ENGLISH HERITAGE

Notifications under Circular 01/2001, Circular 08/2009 & GDPO 1995
DUTTON HALL, GALLOWES LANE, RIBCHESTER, LANCASHIRE, PR3 3XX
Application No 3/2011/0931

The proposal is to install 21 solar panels on the south roof slope of the Grade II listed former barn.

Proposed Site and Roof Plan
Scale 1:200 at A3
Date 29 Oct 2011
Drawing No 291011/4

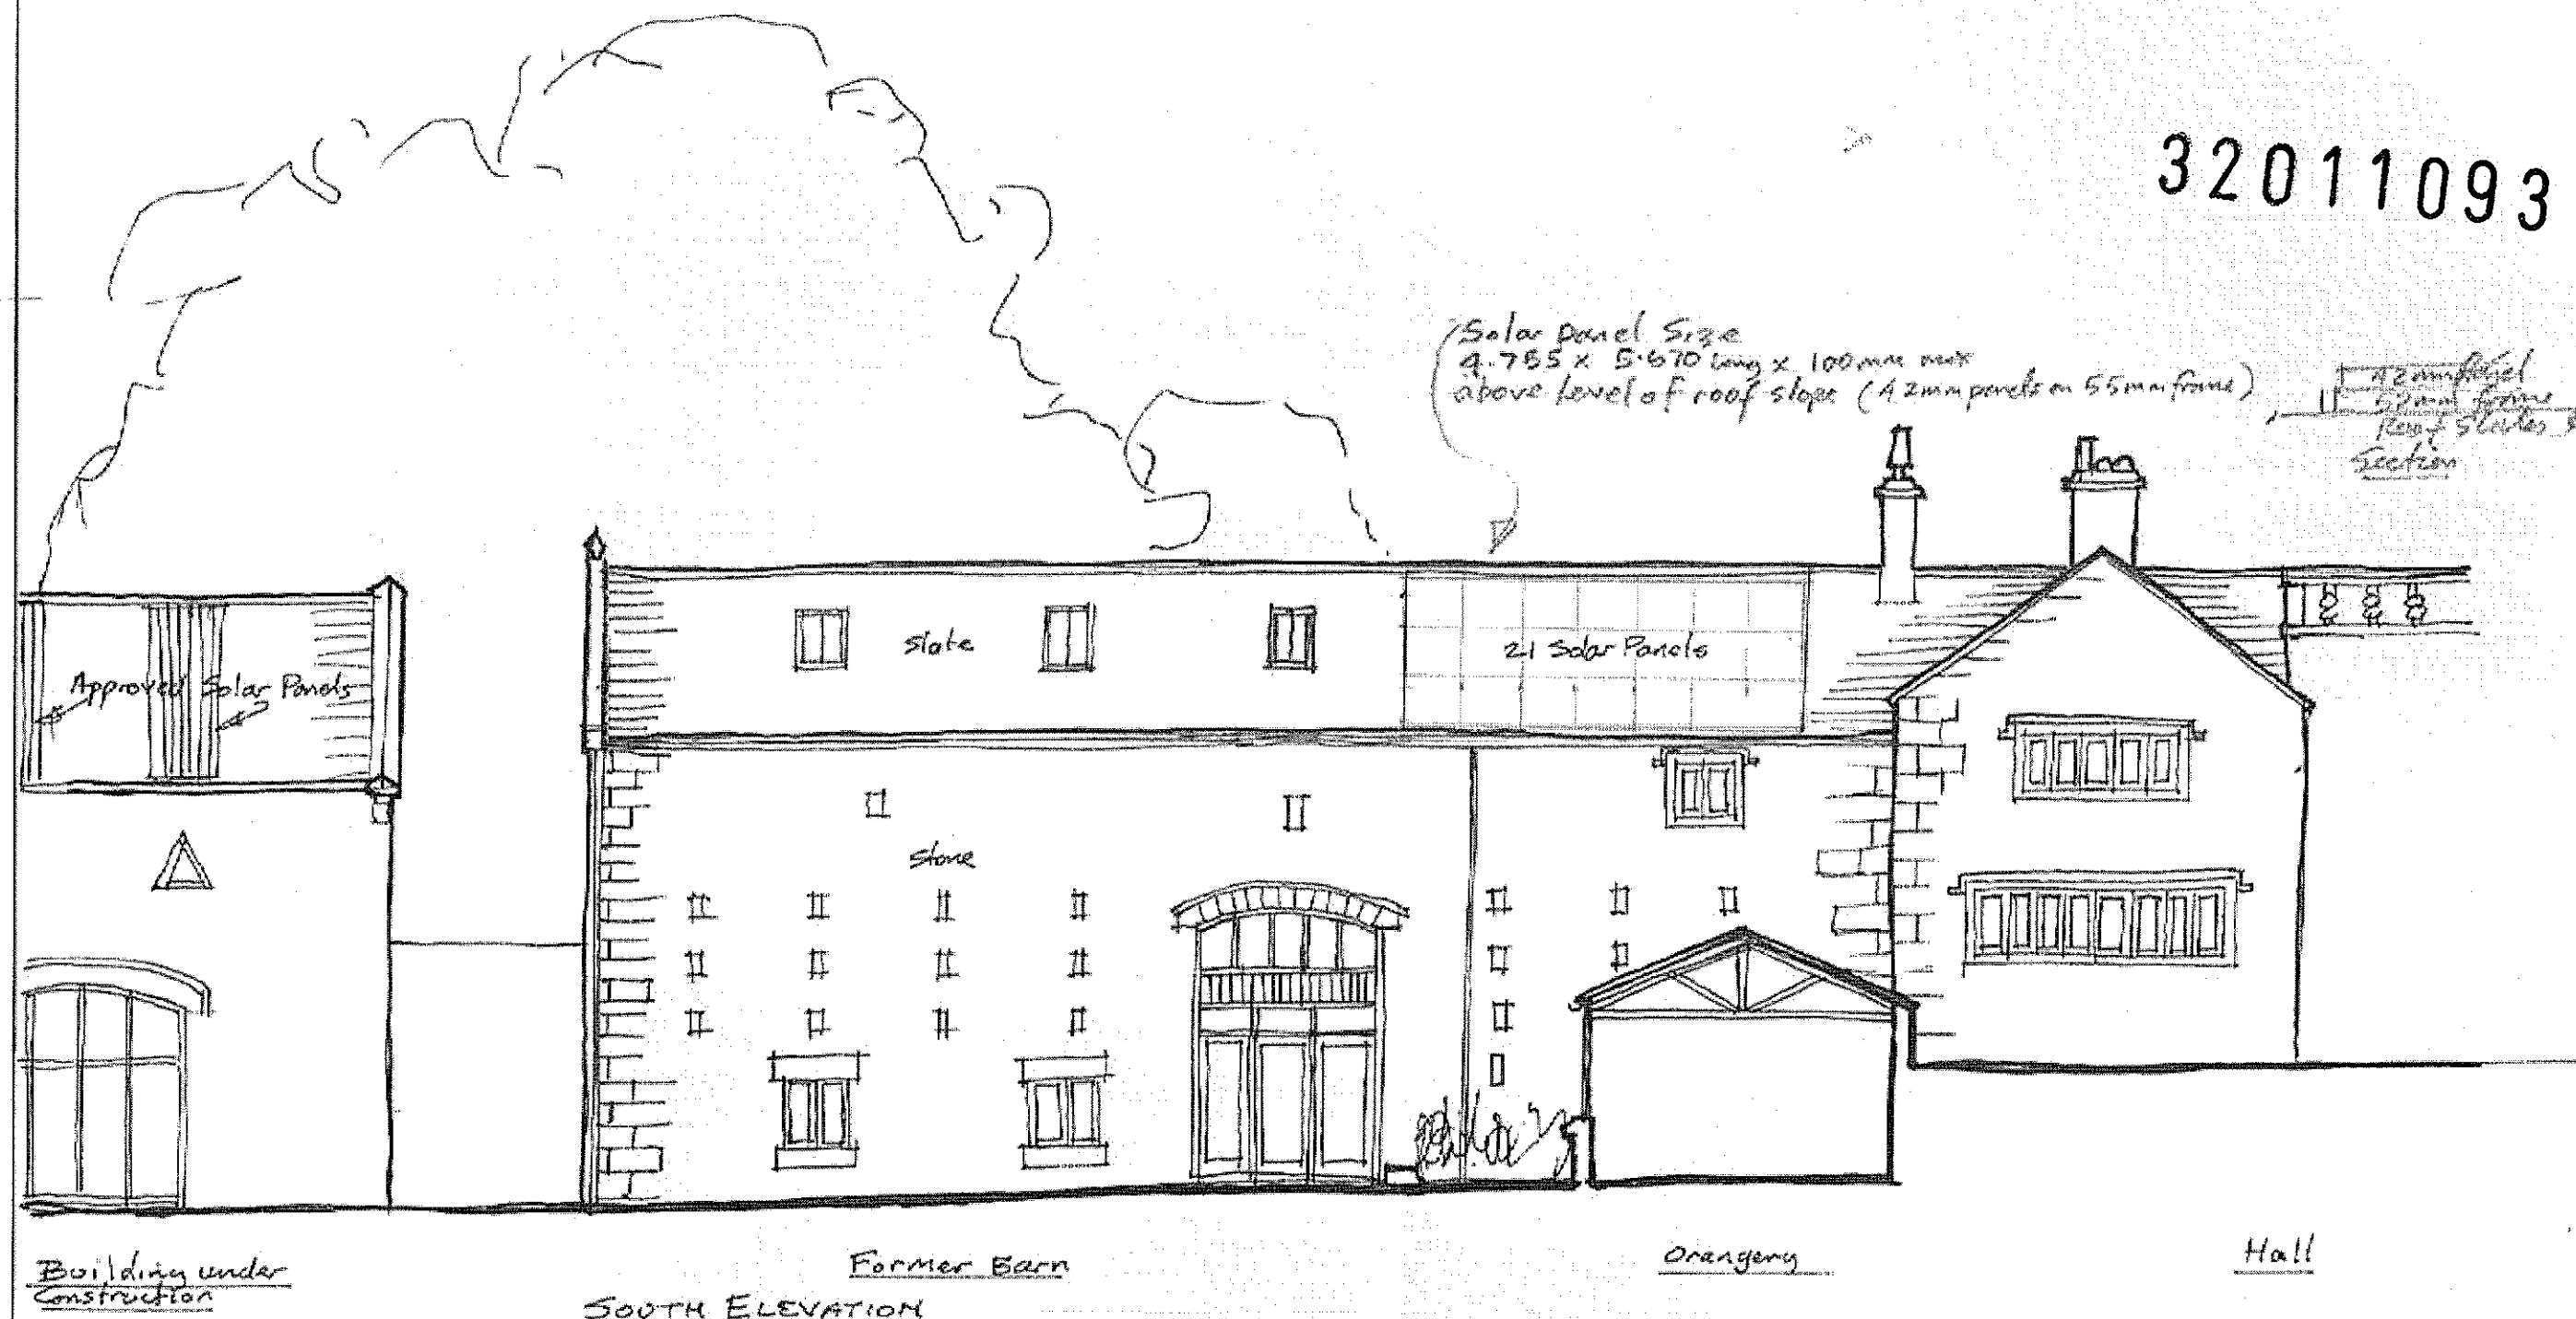
In our view, the proposal would have a harmful impact on the significance of the Grade II listed barn and the setting of the Grade II* listed Dutton Hall.

PPS5 requires a description of the significance of the heritage assets affected and the contribution of setting to that significance to be provided by applicants and in our view this is not adequately addressed in the information submitted. Nevertheless, it is clear that the proposed PV panels would be highly visible in close proximity to the highly significant south elevation of the Grade II* listed Hall and as such, in our view, would detract from its setting and have a harmful material affect on the appearance of the Grade II listed barn.

For the reasons set out above, English Heritage objects to the listed building consent application and we advise that alternative measure to reduce climate change should be explored.
